From: [Jeremy Johnston](#)
To: "Ed Sewall"; [Spencer Parr](#)
Cc: [Kelly Bacon \(CD\)](#); [Jeremy Larson](#)
Subject: Swiftwater Storage CUP and Residential Building Application Parcel 15445
Date: Tuesday, May 25, 2021 10:17:38 AM

Kittitas County CDS, Planning Official

WLC PROPERTY HOLDINGS LLC
SITE PLAN

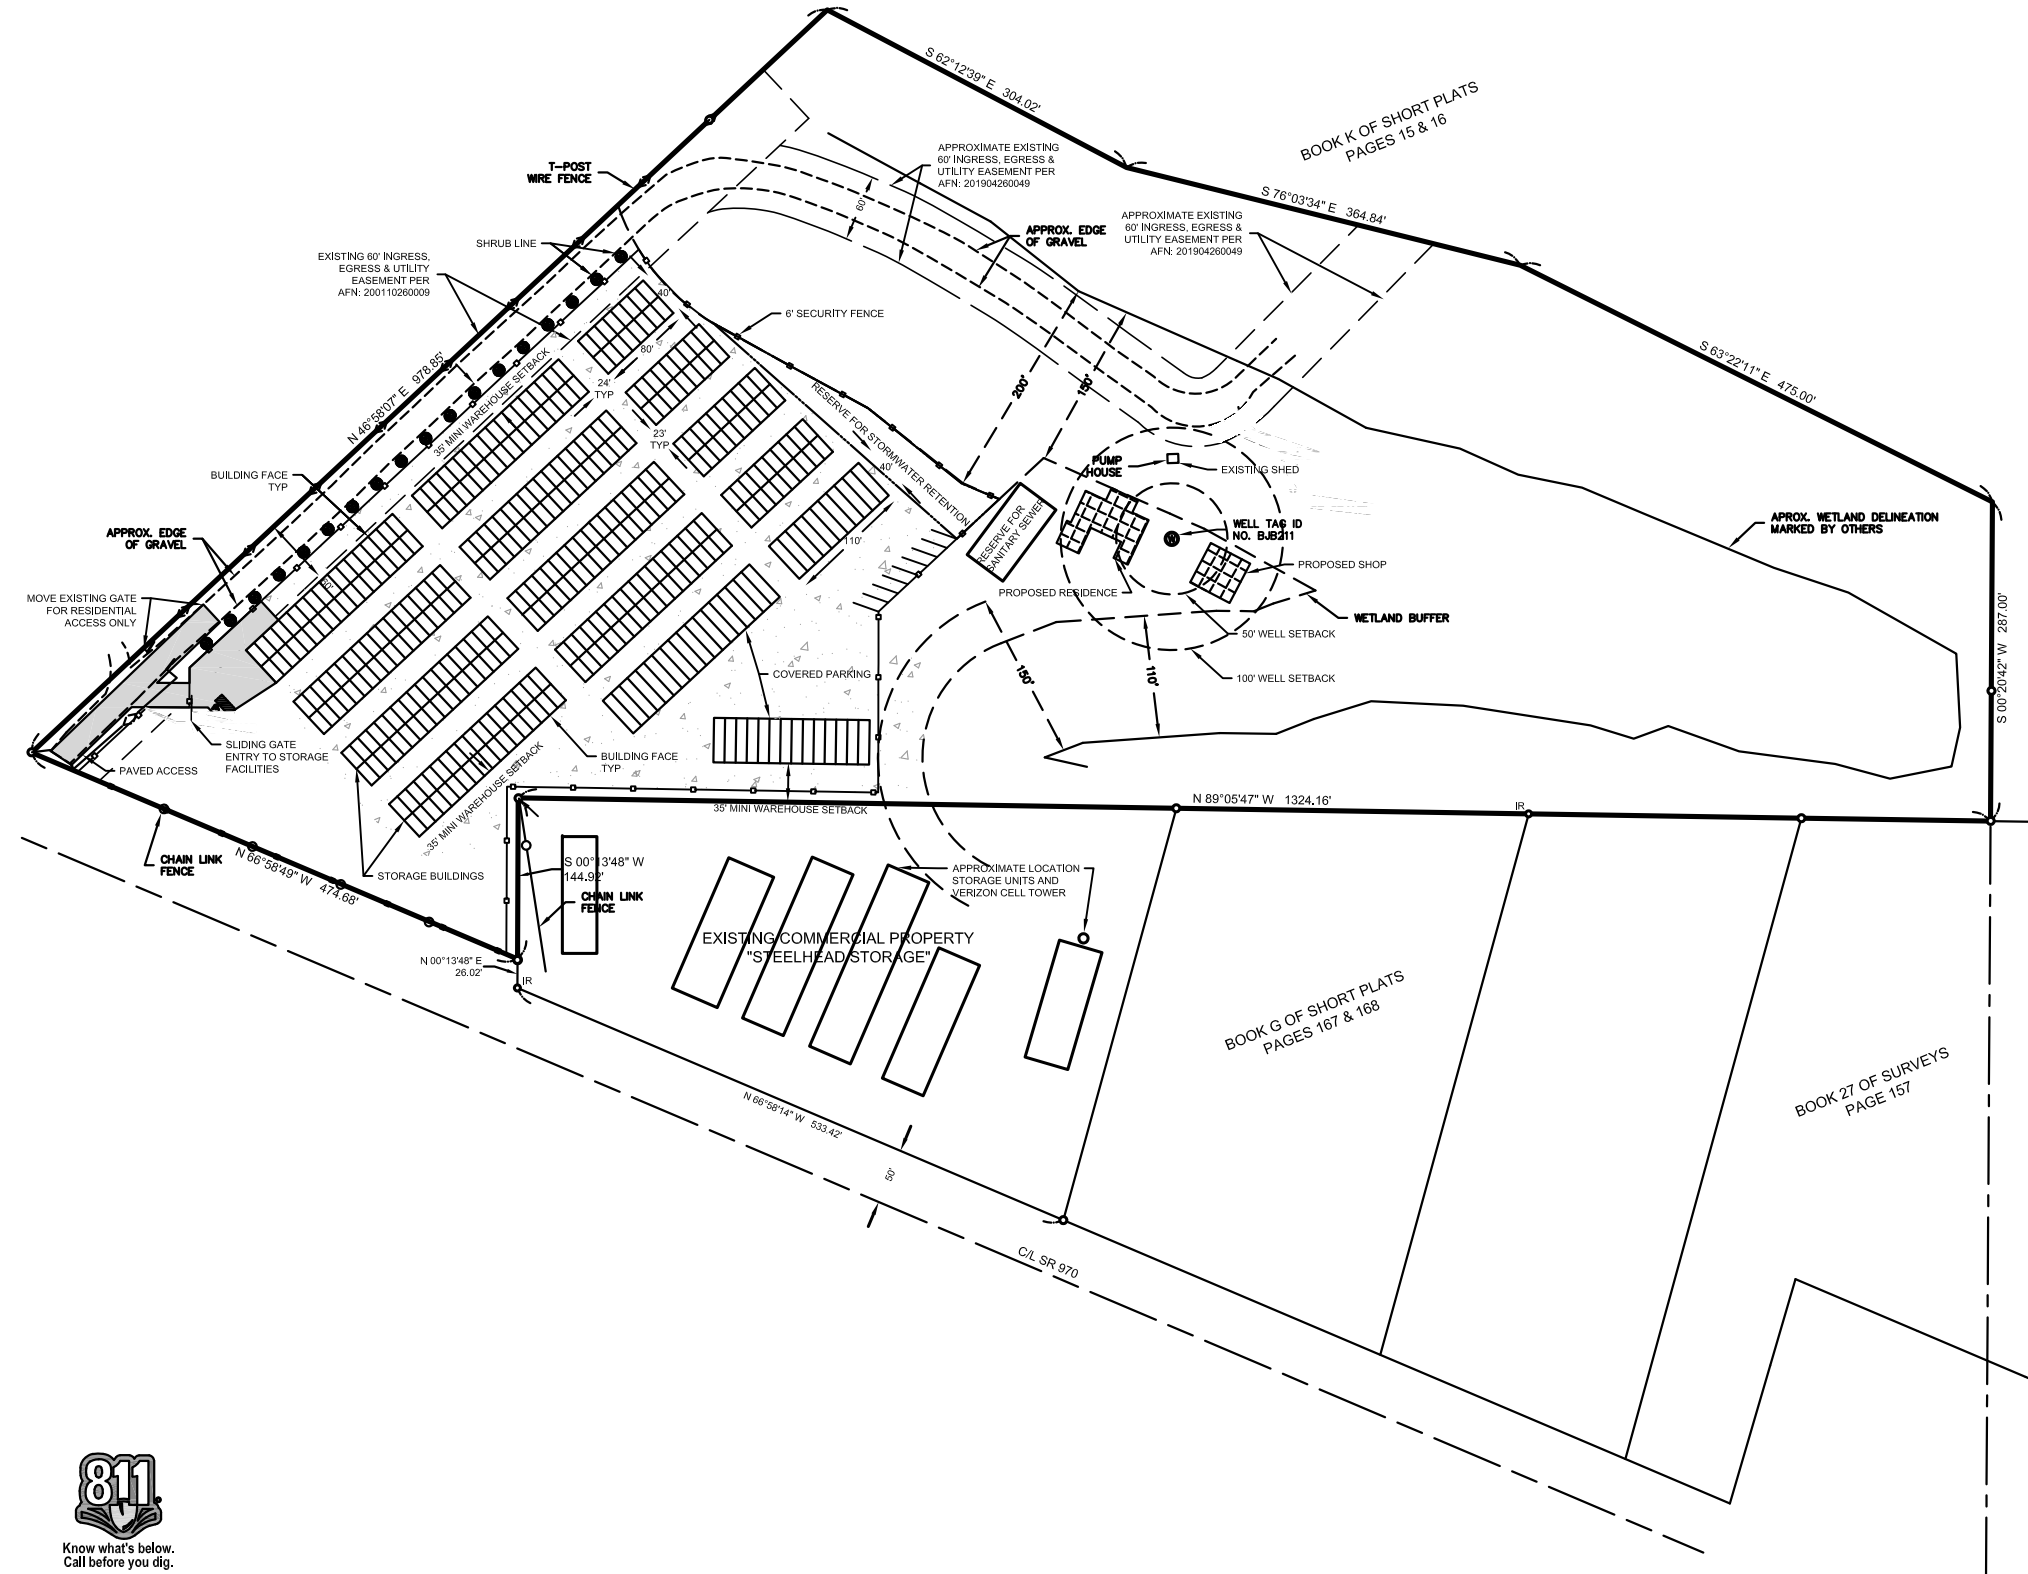
The Commercial Use being proposed under the Swiftwater CUP would be considered a High Intensity Use, which requires a 200 foot structural setback. We will need an updated site plan from the applicant which indicates these updated setback boundaries.

As a side note, regarding the proposed residence on the parcel, the site plan will need to be updated as well for this building application. In this case the residence is considered a moderate intensity use which will require a 150 foot structural setback (see table above). Depending on the precise location of the residence, in reference to this setback line, a Shoreline Exemption may be required.
